RESPONSE TO SUBMISSIONS REPORT
6A WATSFORD ROAD, CAMPBELLTOWN
SSDA FOR CONSTRUCTION OF A TWO STOREY SCHOOL BUILDING WITH
BASEMENT PARKING

Prepared on Behalf of: Warakirri College

Prepared by: Planning Lab

Issue Date: 11 June 2020

GROUND FLOOR PLAN

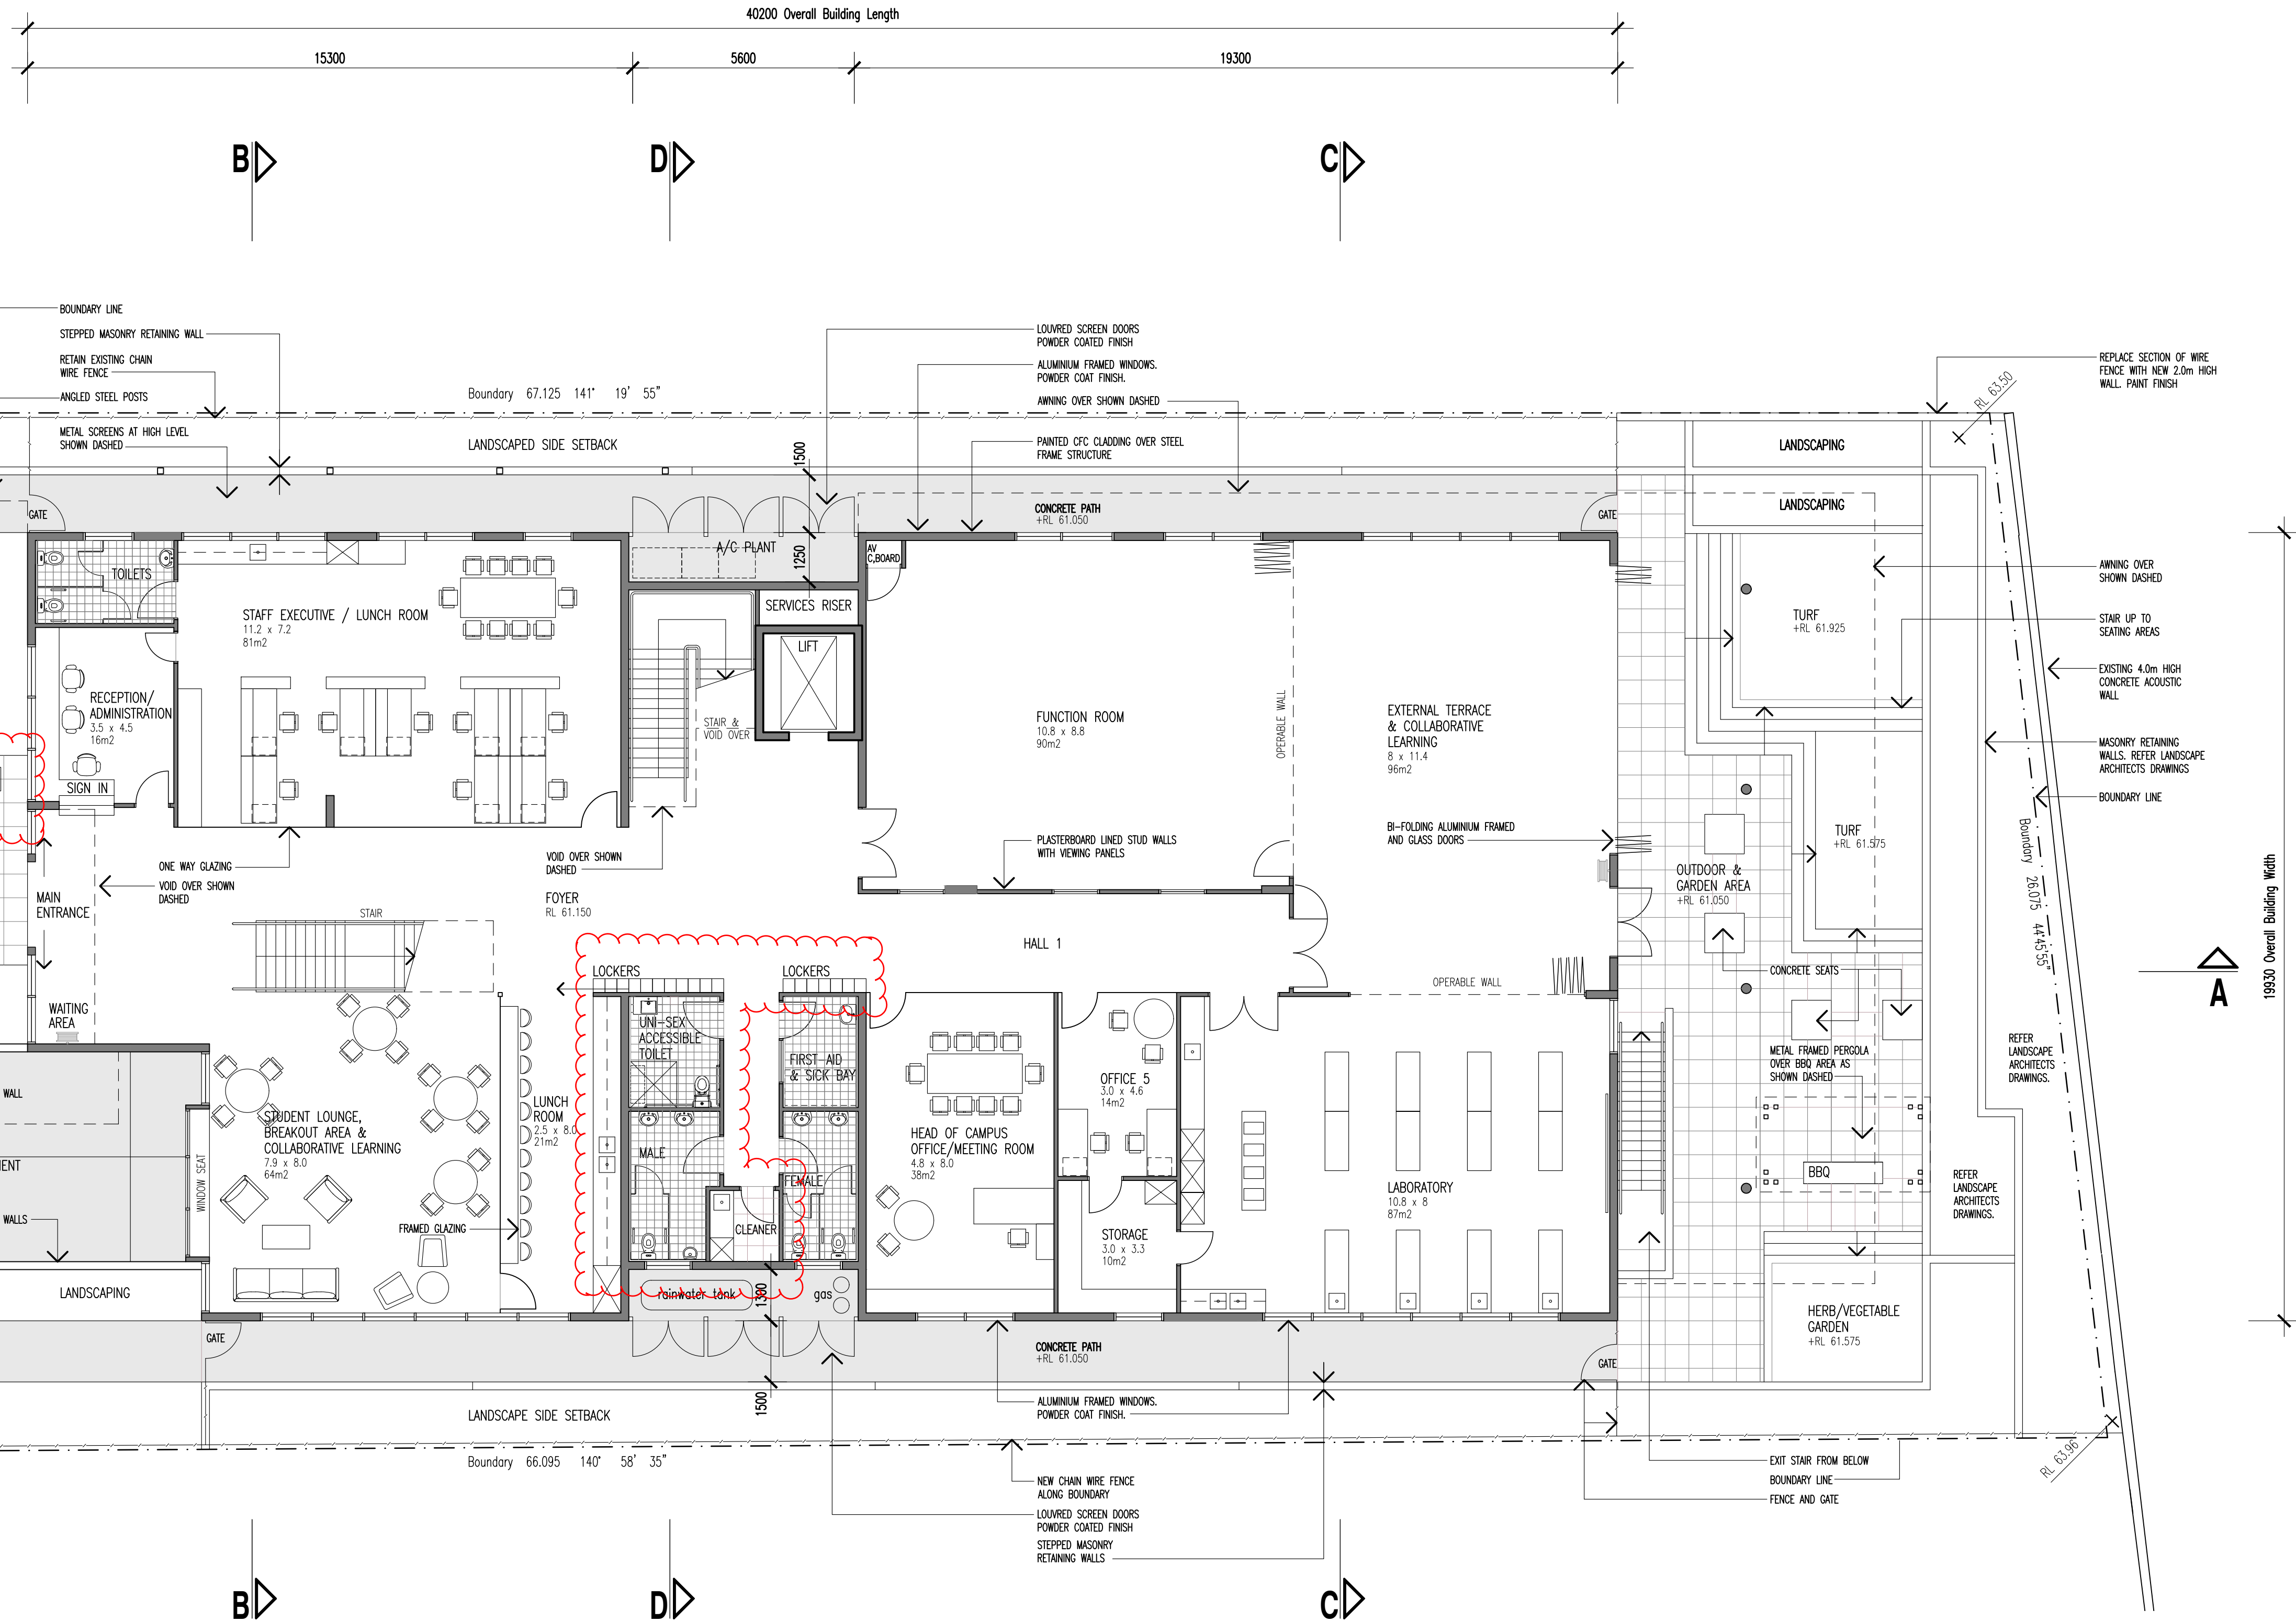
<p>4. End of trip facilities</p> <p><i>Provide details of any end-of-trip facilities proposed for the site, including their location.</i></p>	<p>The updated drawing set has shown shower facilities added into the uni-sex accessible toilets on both Ground and Level 1 on drawings A-03-C and A-04-C. Stacks of lockers have also been depicted on both Ground and Level 1 near the shower facilities. The accessible bathrooms are self-contained and private. They provide the most appropriate location within the College for shower facilities serving both staff and students.</p>
<p>5. Aboriginal cultural heritage</p> <p><i>Provide details on information considered in relation to evidence of Aboriginal cultural heritage significance of the site.</i></p>	<p>The site is shown on the Campbelltown City Council Local Government Area Zones of Aboriginal Archaeological Sensitivity to be in an ‘urban/industrial’ area (appendix A). The site is located within a disturbed industrial park and is not known to contain any items of aboriginal heritage.</p>
